**WEST SUSSEX COUNTY COUNCIL
PLANNING SERVICES CONSULTATION**

SUBJECT: FP/177/17/OUT- Outline application with some matters reserved for 1 No. dwelling.

Rear of, 9 Downview Road, Felpham, PO22 8HG

Proposed Ground
Floor Plan

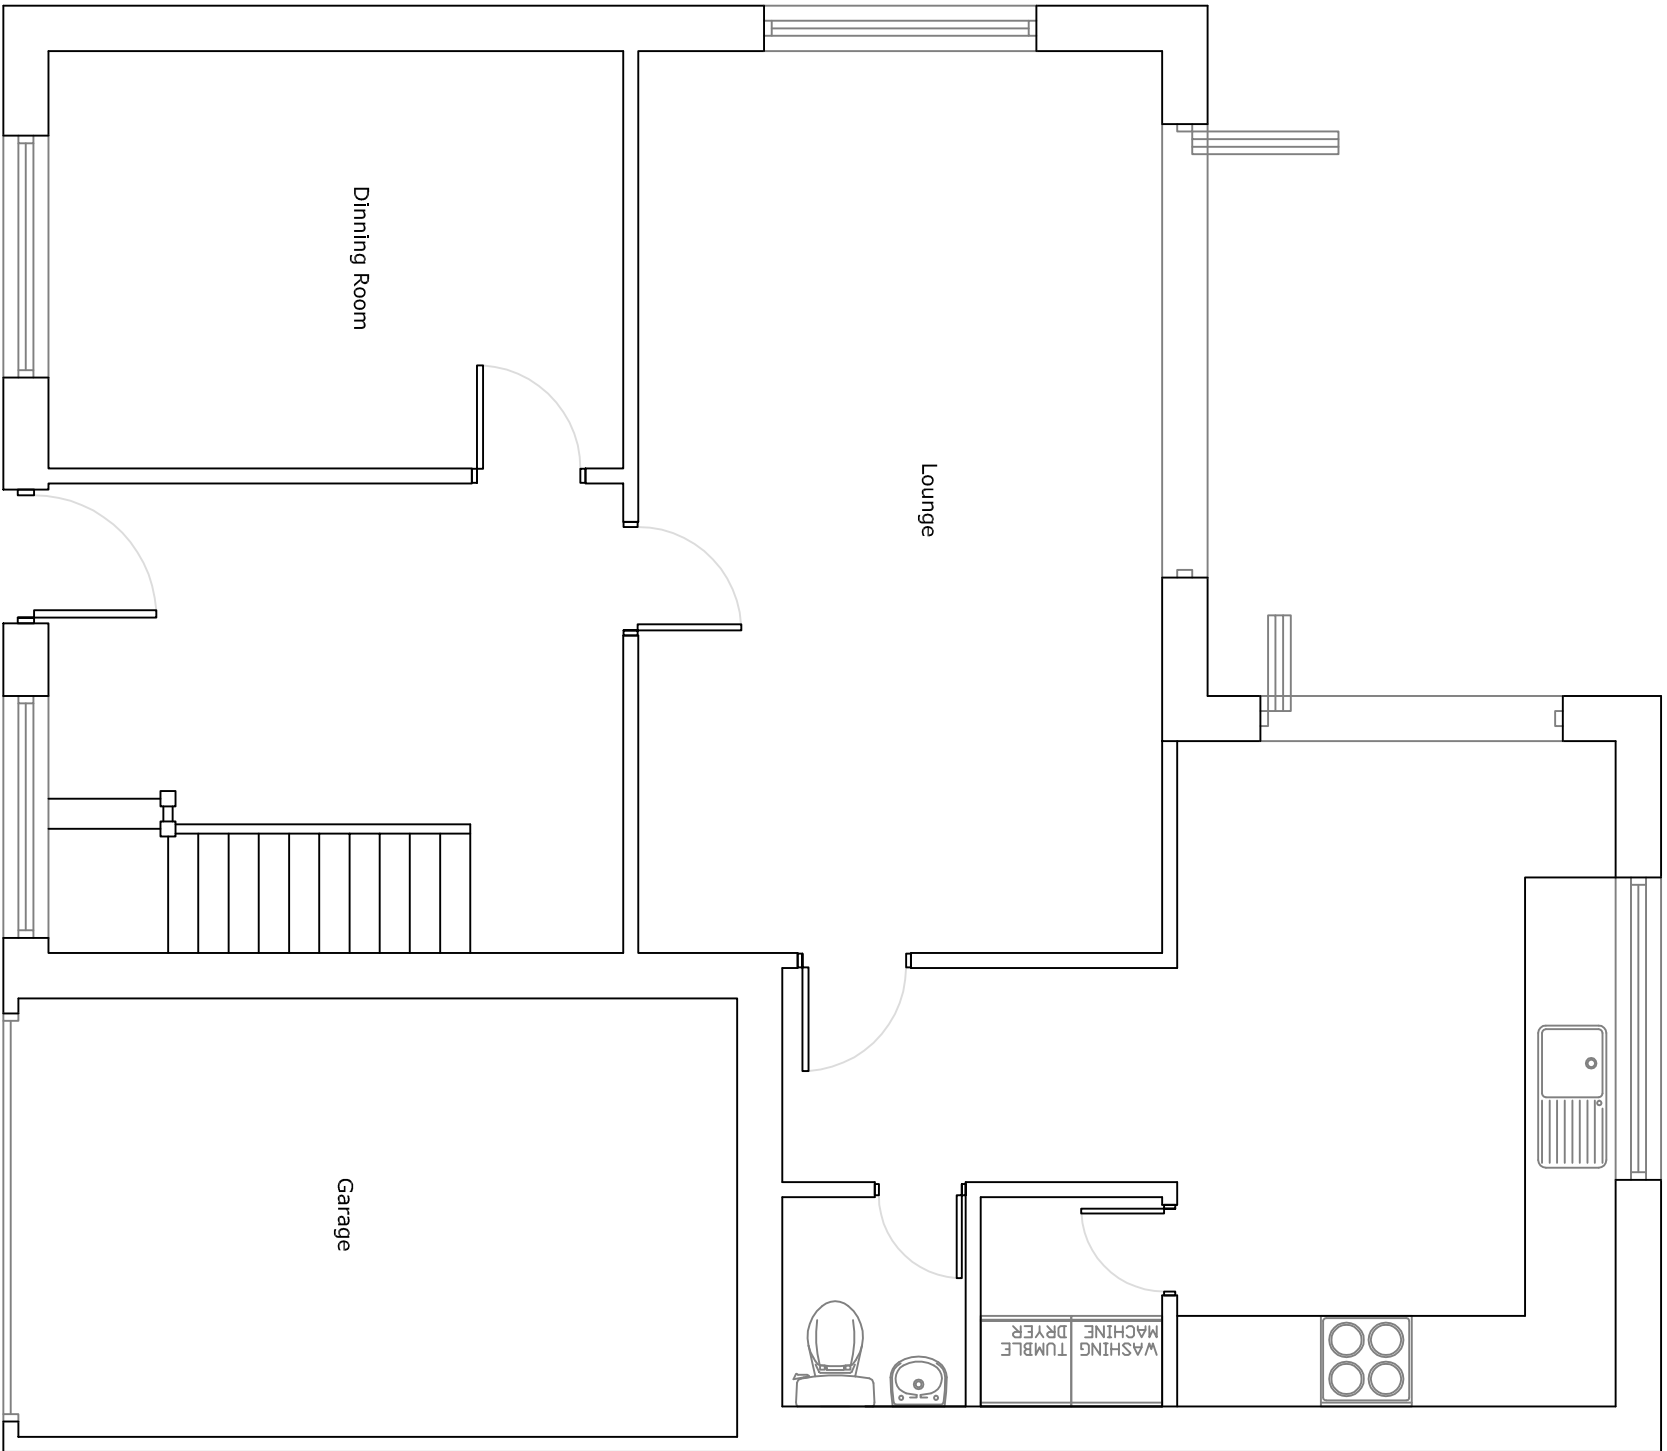
Two parking spaces are demonstrated on the hardstanding fronting the proposed property and a single garage space. The garage space is substandard by WSCC standards; the garage measures 2.9 x 4.8m whereas WSCC standards denote that 3m x 6m would be acceptable. Space does exist within the site to achieve these garage dimensions and should be conditioned alongside any permission of this application.

Adequate space is achievable fronting the proposed property for parking and space is available for a turn on site to be provided although the landscaping has not been demonstrated within the documentation again this should be demonstrated at the Reserved Matters stage and conditioned alongside any permission.

No part of the development shall be first occupied until the vehicle parking and turning spaces have been constructed in accordance with the approved plan, including garage space of 3m x 6m. These spaces shall thereafter be retained for their designated use.
